Dogger Bank South Wind Farm

Appendix P8 to Natural England's Deadline 8 Submission

**Natural England's Comments on Environmental Statement Conclusions (from Rule 17
letter dated 19 June 2025 [PD-027])**

Planning Inspectorate Reference EN010125

Title:
Location and Indicative sediment transport pathways across Smithic Bank derived from bedform geometry

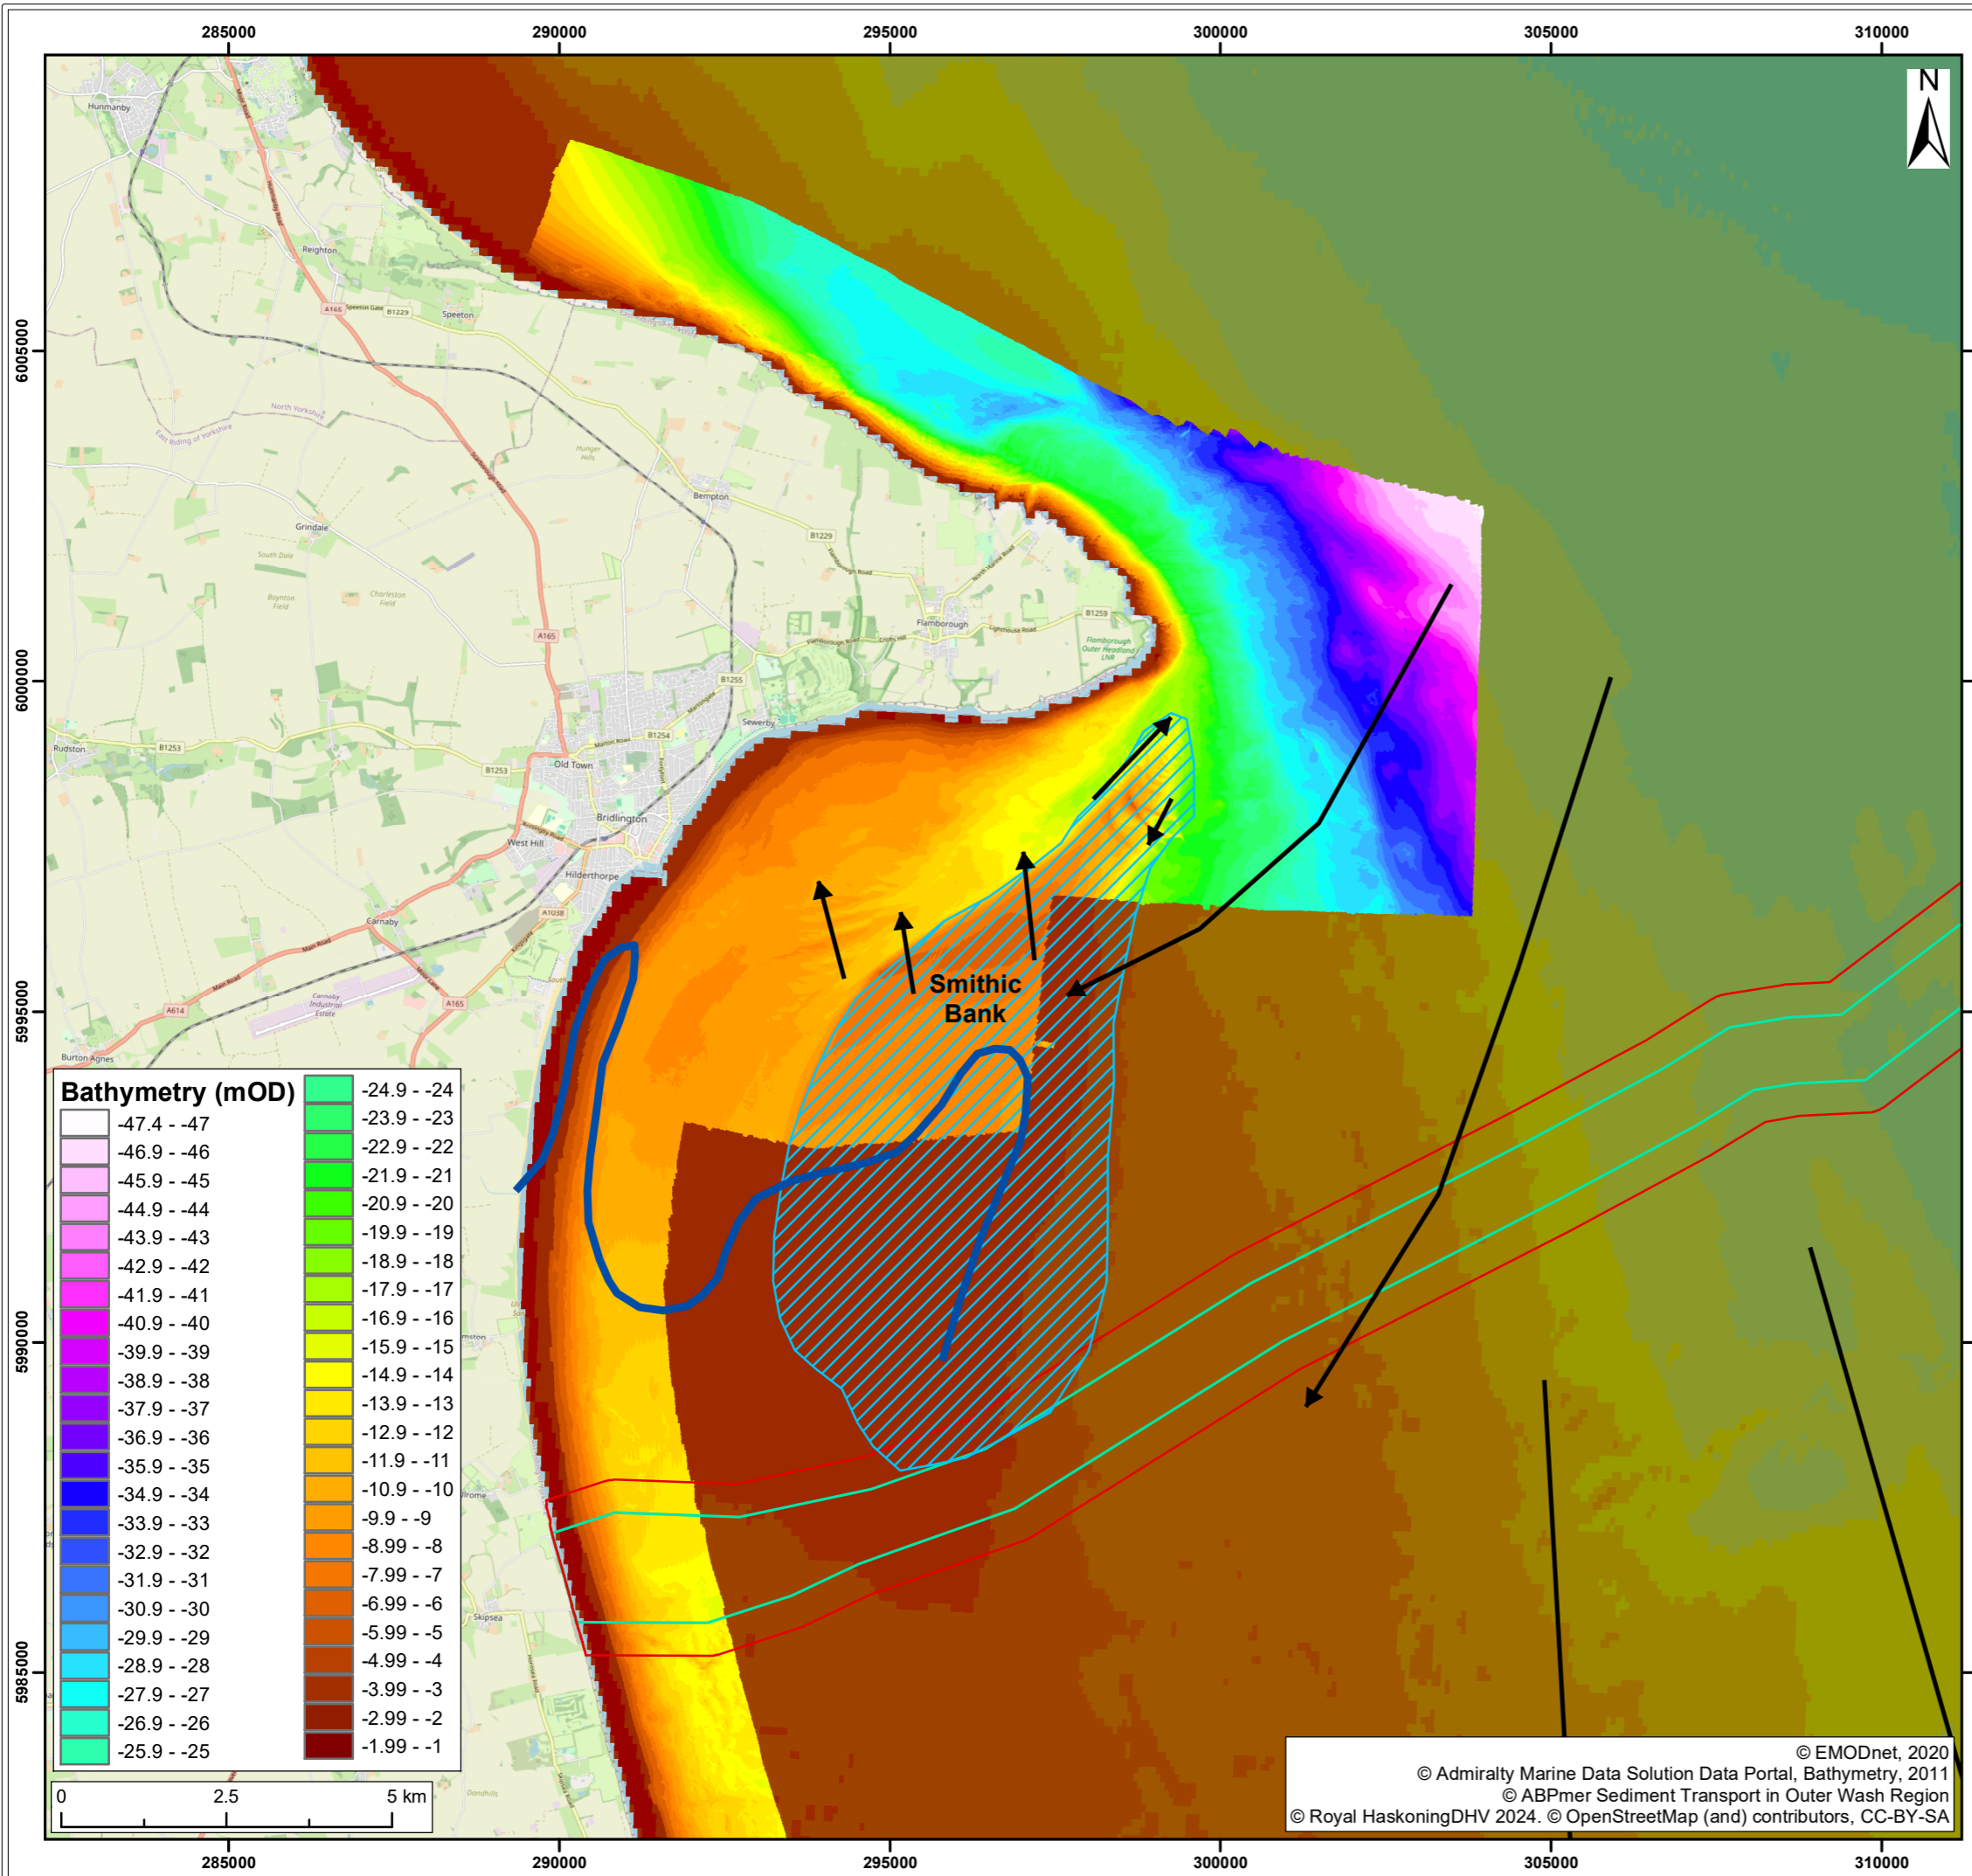
<p>value is high and therefore disagree with the assessment on significance of effect for this receptor summarised in Table 8-71 (Table 8-67) of ES Chapter 8 [REP7-036]. Smithic Bank provides shelter to the northern part of the Holderness Coast including the town of Bridlington. It is an important fish nursery and feeding ground, in turn supporting the birds at Flamborough Head. [R&I, B25]</p> <p>We advise that as a minimum this could be addressed though adopting similar requirements placed on Hornsea Project 4 i.e. pre-construction update of modelling of the final built out design and inclusion of monitoring.</p> <p><u>Decommissioning</u></p> <p>Natural England maintains our previous advice (B44 [RR-039]) and continue to disagree with the Applicant's assessment that the magnitude of decommissioning effects on the marine physical environment can be assumed to be comparable to those during the construction phase. We consider that the baseline conditions at the end of design life may differ significantly from those at pre-construction and the value of receptors may change over the lifetime of the project. Consequently, the EIA cannot confidently determine decommissioning impacts at the end of the design life of the Projects. [R&I, B30]</p>
